November 17, 2022

Project: GAAR 1635 University Blvd. Renovation and Addition-Permit Reference H15-D008

Subject: Reference Letter dated November 7, 2022-Traffic Circulation Layout Review

A1 TRAFFIC PLAN
1" = 40'-0"

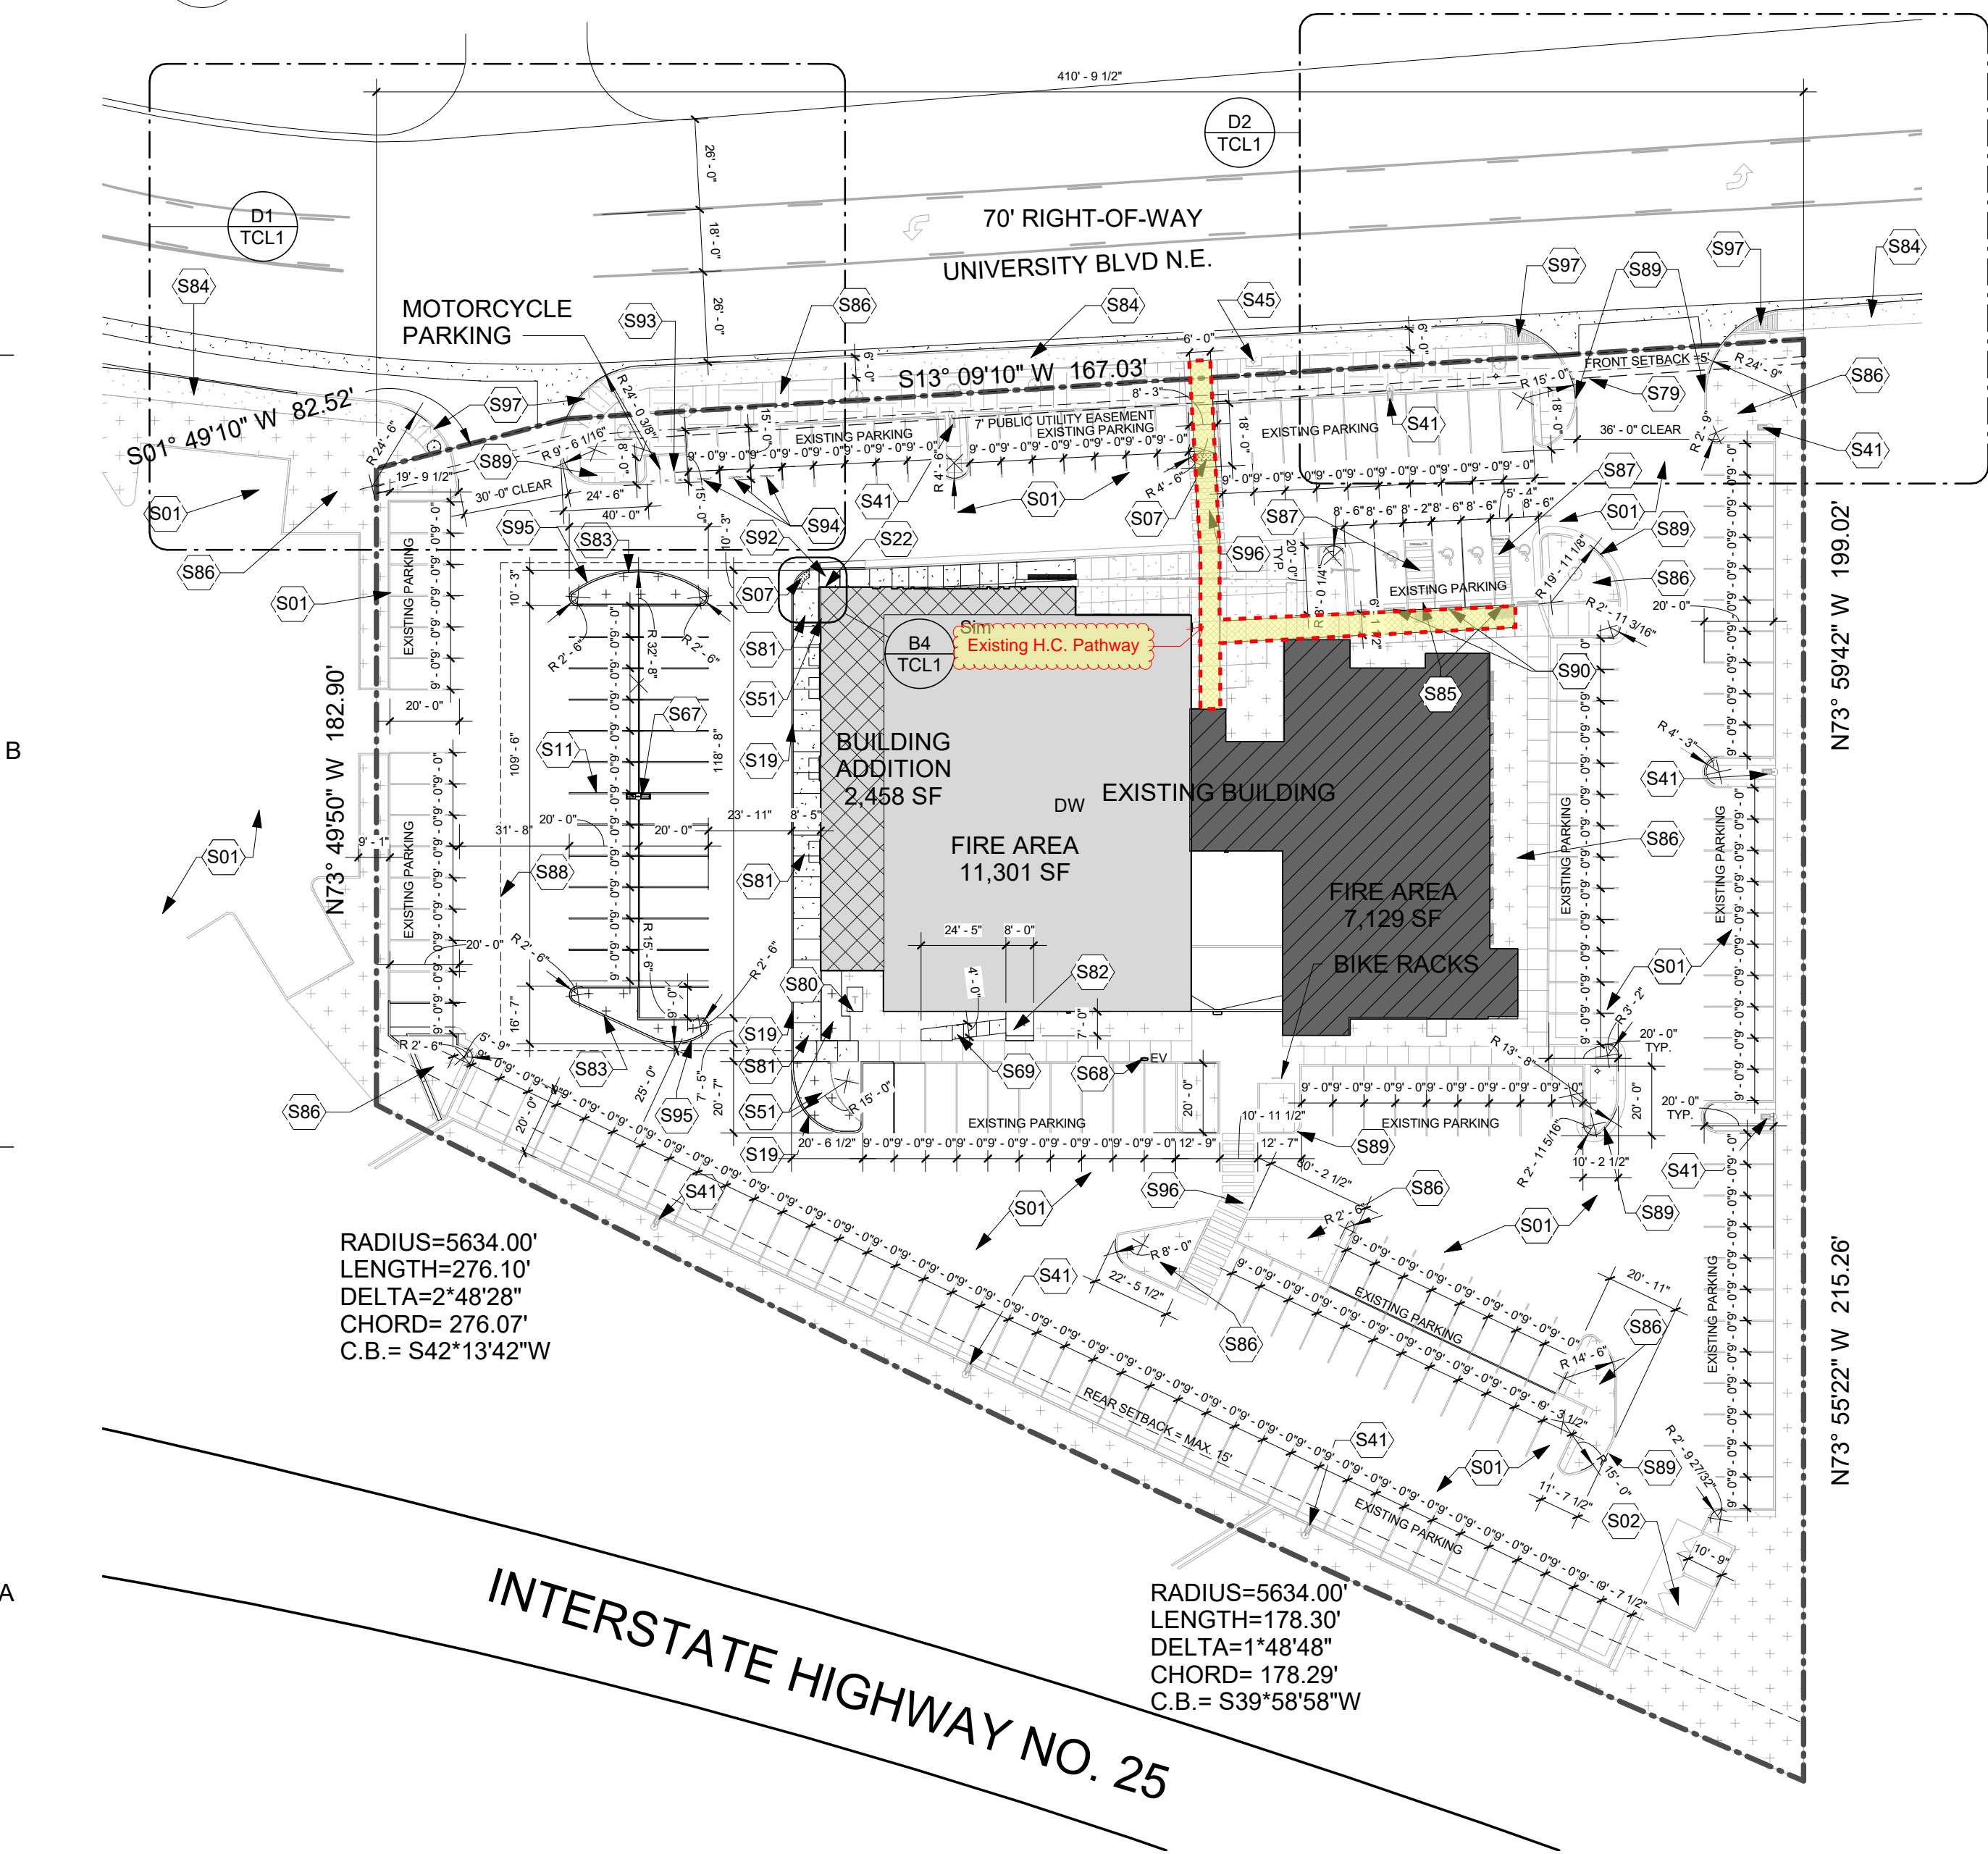
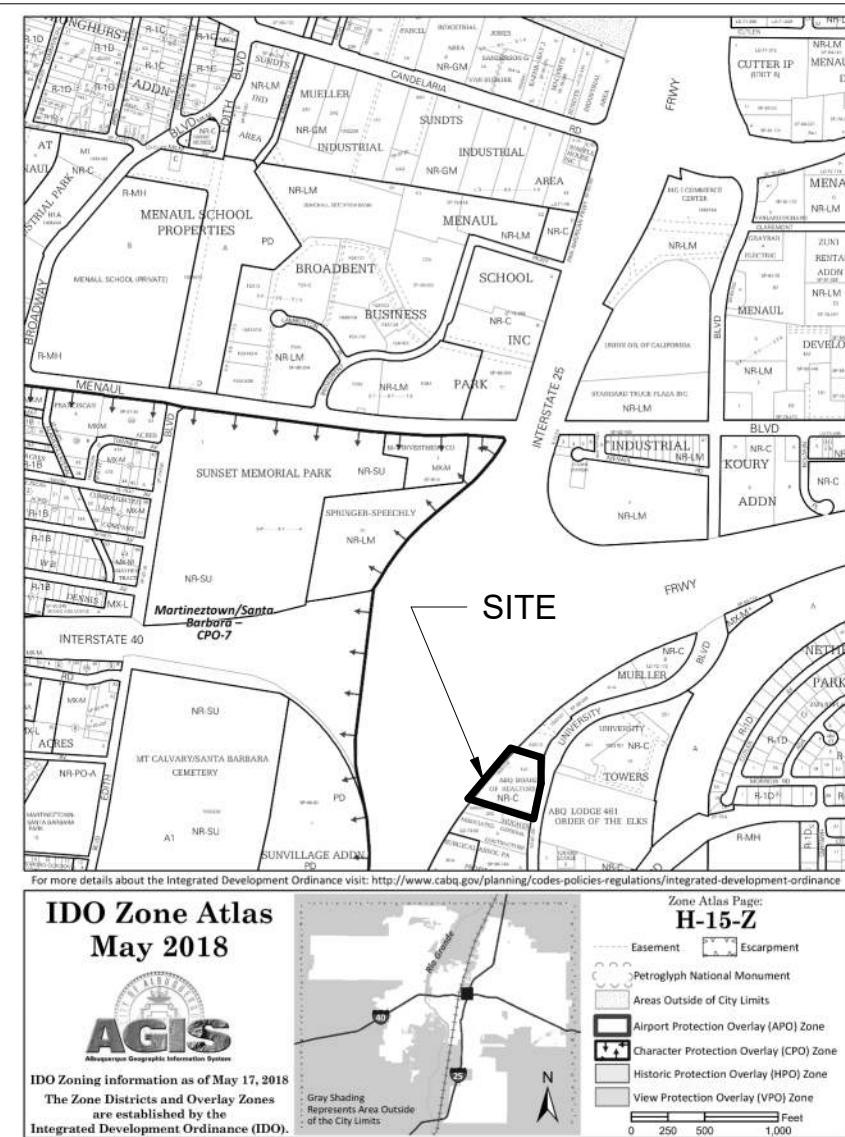
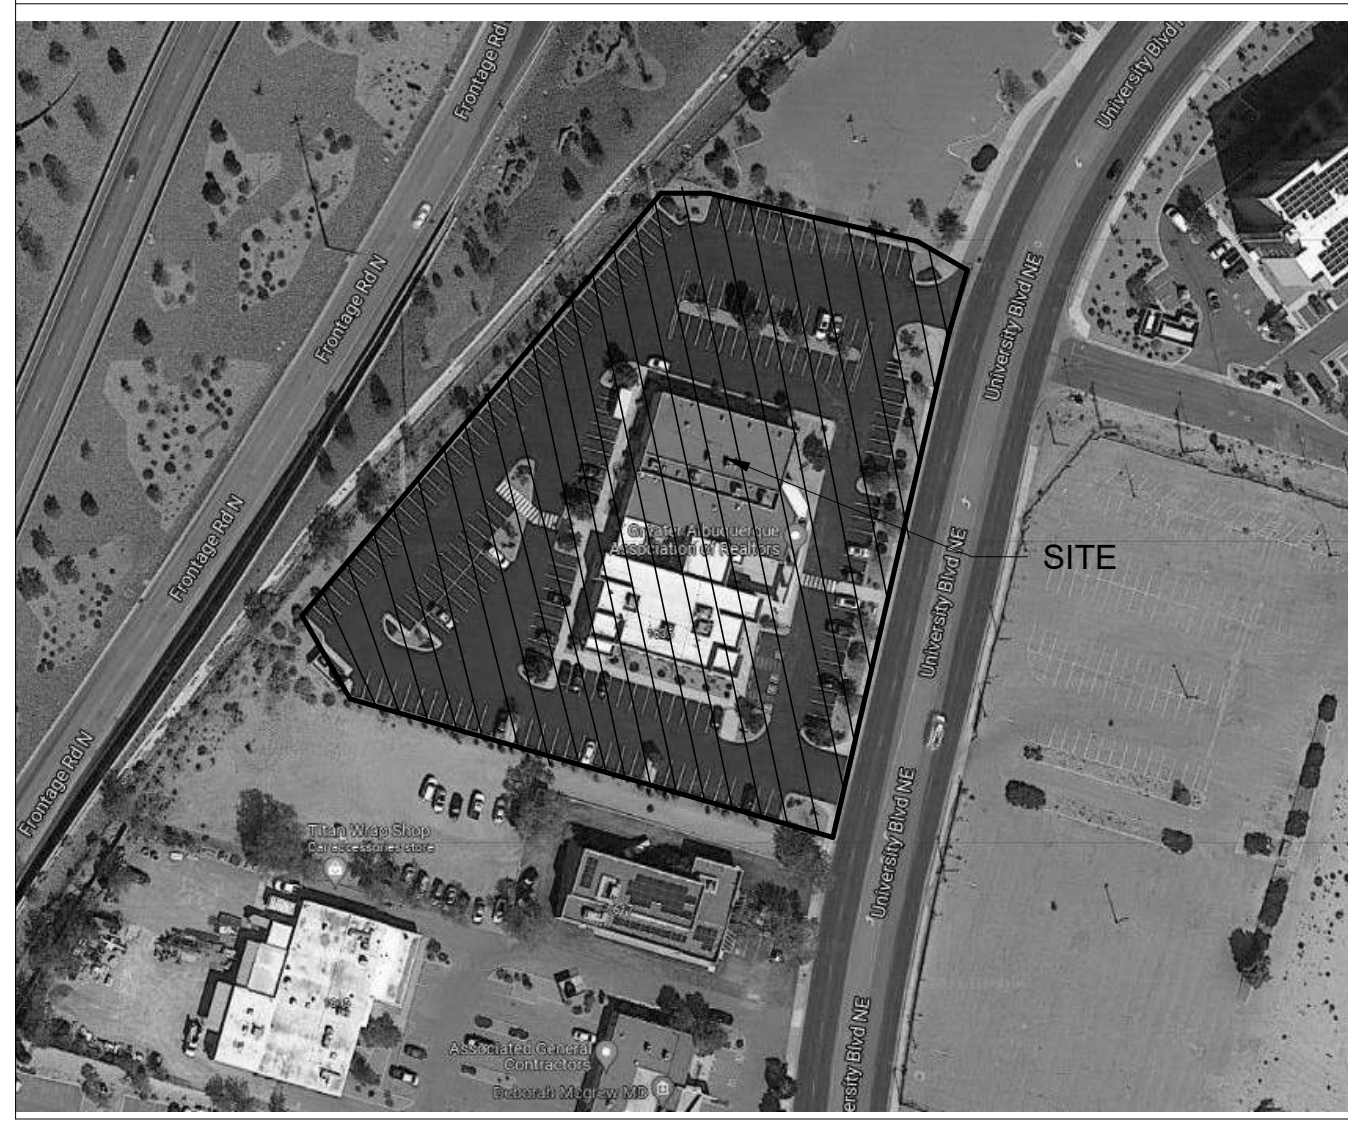
1. Label the compact parking spaces by placing the words **"COMPACT"** on the pavement of each space.  
RESPONSE: Stenciled lettering on the asphalt paving to read "COMPACT" shall be added as part of the project and as shown in the revised TCL Plan.

2. Keynote S01: the aerial shows the parking spaces striping is fading. I'd like to request restripe the parking spaces if applicable.  
RESPONSE: ADA spaces will require restriping –Repainting of striping shall be included in the project.

3. Key note S69: The minimum width for the pathway should be 4 ft.  
RESPONSE: New pathway shall be adjusted to 4 ft as shown on the revised TCL.
4. Key note S81: Call out COA std dwg 2430.

RESPONSE: Revised keynote to callout per COA std dwg 2430 for required slopes only.
5. Key note S82: Please add a note stating that the max. slope for the landing area should be 2% in all direction.

RESPONSE: Added face sign details on sheet TCL2.
7. Key note S96: Per the IDO, a 6 ft. wide ADA accessible pedestrian pathway is required from the public sidewalk to the building entrances. Please clearly show this pathway and provide details.

8. Keynote S97: ADA curb ramps must be updated to current standards and have truncated domes installed.

10. Show all drive aisle widths and radii. Some dimensions are not shown.

11. The pavement marking "MC" should be shown in the opposite direction for Motorcycles entering the parking space.

12. Per DPM, a 6 ft. wide ADA accessible pedestrian pathway is required from the ADA parking stall access aisles to the building entrances. Please clearly show this pathway and provide details.

15. Please provide a sight distance exhibit.

16. Show the clear sight triangle and add the following note to the plan: "Landscaping and signage will not interfere with clear sight requirements. Therefore, signs, walls, trees, and shrubbery between 3 and 8 feet tall (as measured from the gutter pan) will not be acceptable in the clear sight triangle."

RESPONSE: Added keynote S82 that add stating that the max. slope for the landing area should be 2% in all direction.
6. Key note S90: Please provide face sign details.

RESPONSE: Hatched pathway added on TRAFFIC PLAN to reflect existing condition.

RESPONSE: Response: Most of the existing ramps have tactile grooves, not truncated domes. Those are to remain. New ramps and existing ramps, without tactile grooves, will include installation of new City standard truncated domes as shown on the attached, detail B4, sheet TCL1 drawing.

Response: Dimensions have been added on revised TRAFFIC PLAN, TCL1.

RESPONSE: "MC" to be painted on asphalt paving.

RESPONSE: Hatched pathway has been added on TRAFFIC PLAN. Also illustrated below.

RESPONSE: The sight distance has been adjusted and corrected, see revised TCL plan.

RESPONSE: This note is in the CLEAR SIGHT TRIANGLE notes. The current design complies with the requirements.
